Subject: Williams Shoreline Substantial Development Permit (SD-18-00001)

Enclosed are the comments received regarding the Williams Shoreline Substantial Development Permit (SD-18-00001) during the comment period:

RE: WDFW comments on SD-18-00001 Williams Shoreline Substantial Development along Manastash Creek

DRIVEWAY AND BRIDGE SITE PLAN  
DRAWING 10

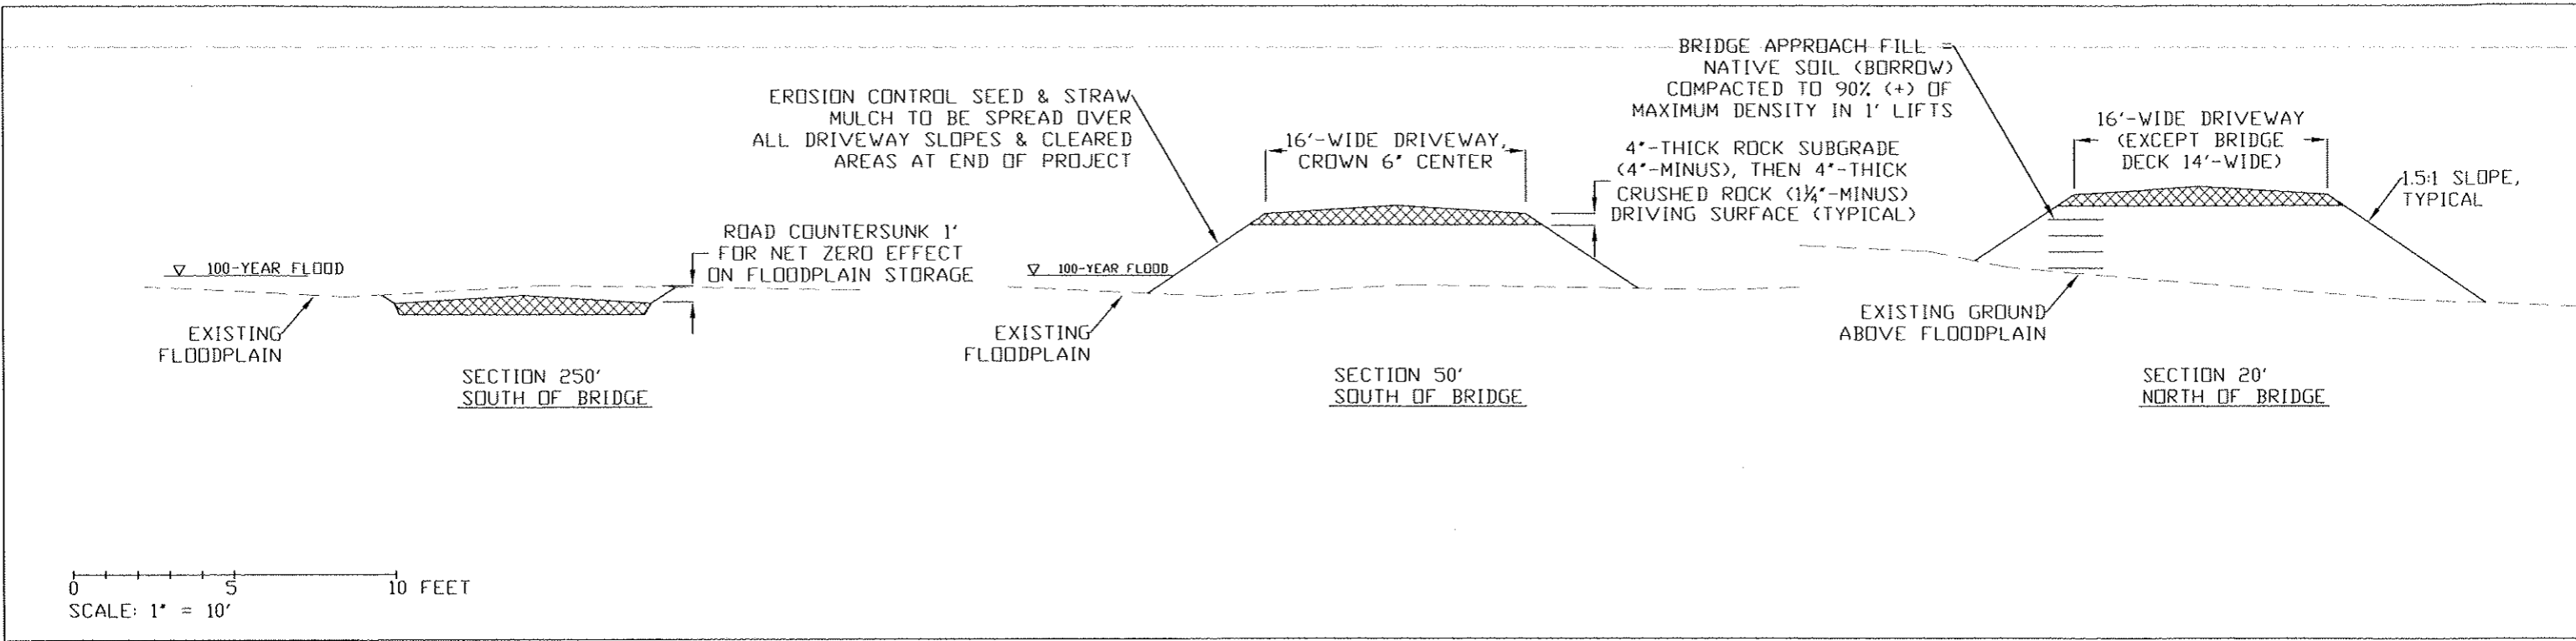
While the application materials may be sufficient for hydraulic project review, they lack information needed for the Shoreline Development Permit review. The application materials do not reflect the clearing or fill (grading) needed for driveway construction through the vegetated riparian habitat and Shoreline designated as Rural Conservancy. In the SEPA checklist, the area of disturbance and impervious surface only describes the footprint of the bridge deck (14' x 60') and does not describe actions within the Shoreline jurisdiction that will occur to construct the driveway on either side of the proposed bridge. Without this information, it is difficult to assess impacts to the Shoreline environment, critical areas, or the 100 year floodplain. The riparian corridor along Manastash Creek provides habitat for fish and wildlife and it helps to stabilize the

Please provide additional information for the design and construction of the driveway associated with the proposed bridge and any other work that is proposed within the Shoreline jurisdiction.
